EPC STORMWATER REVIEW COMMENTS
IN ORANGE BOXES WITH BLACK TEXT

2290 OLD RANCH ROAD

DESCRIPTION:
FERRANTI RESIDENCE
2290 OLD RANCH ROAD

EPC's EDARP File Number: CDR2320

## DISTURBED AREA

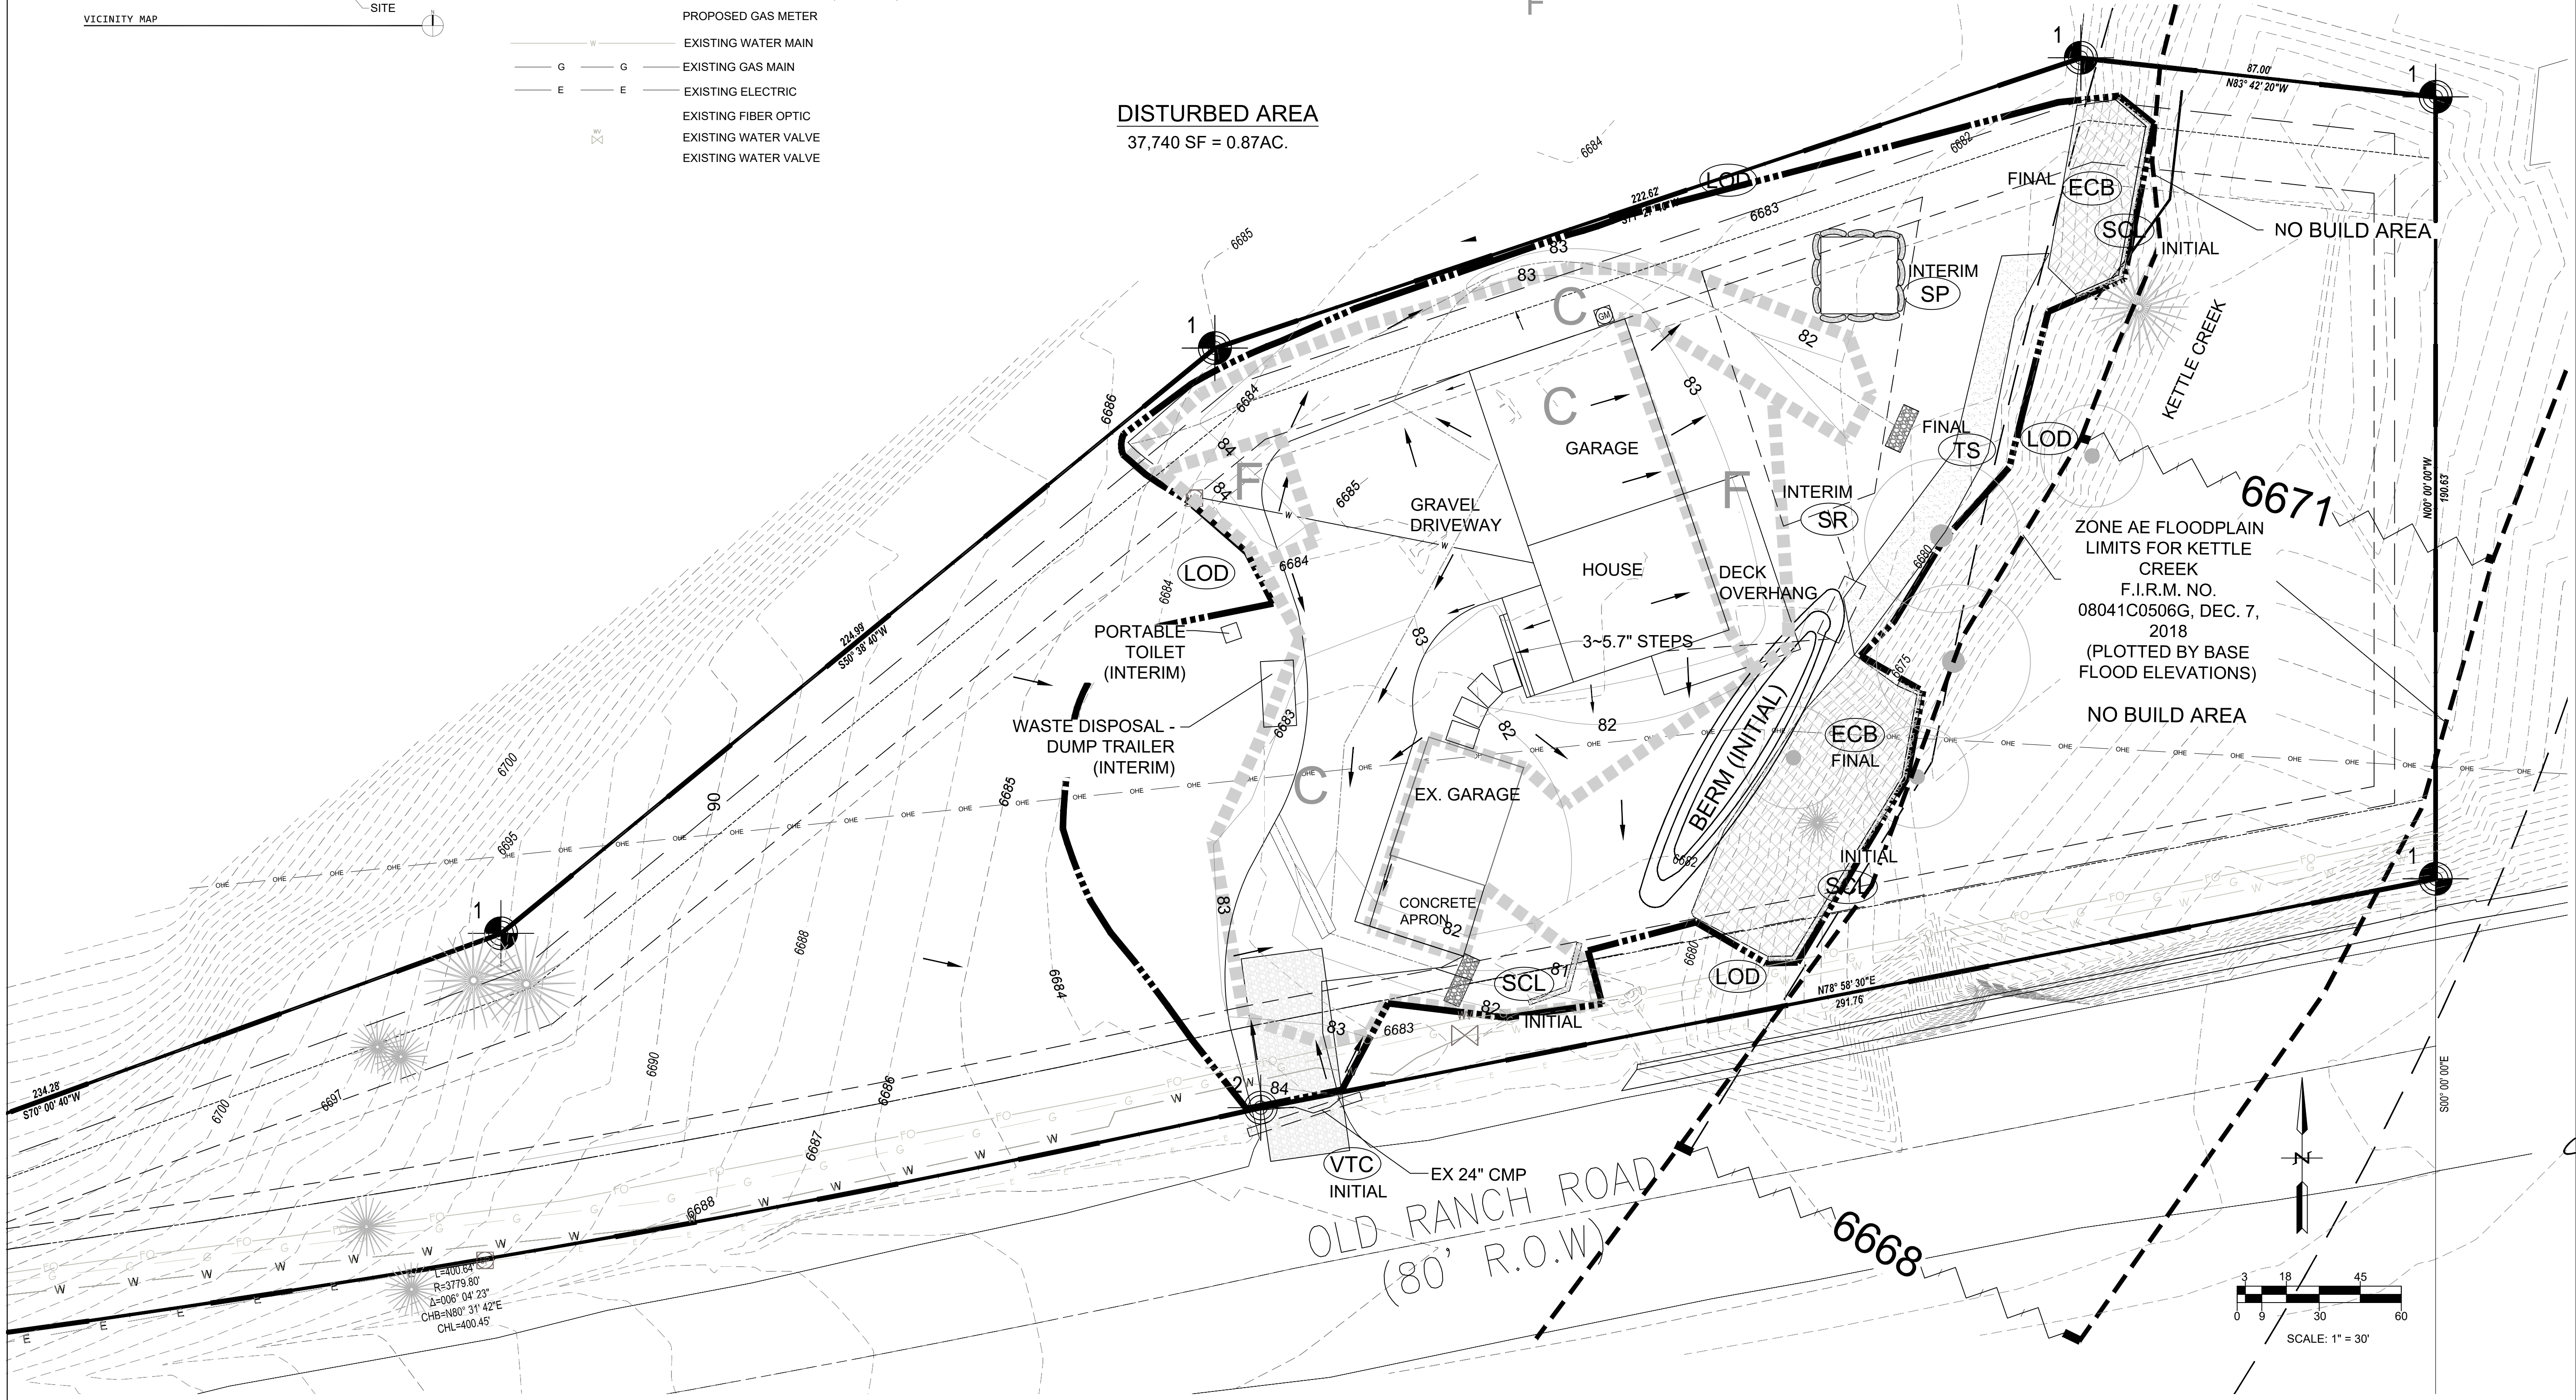
show in legend

Site Plan to be certified
by a registered Colorado
PE
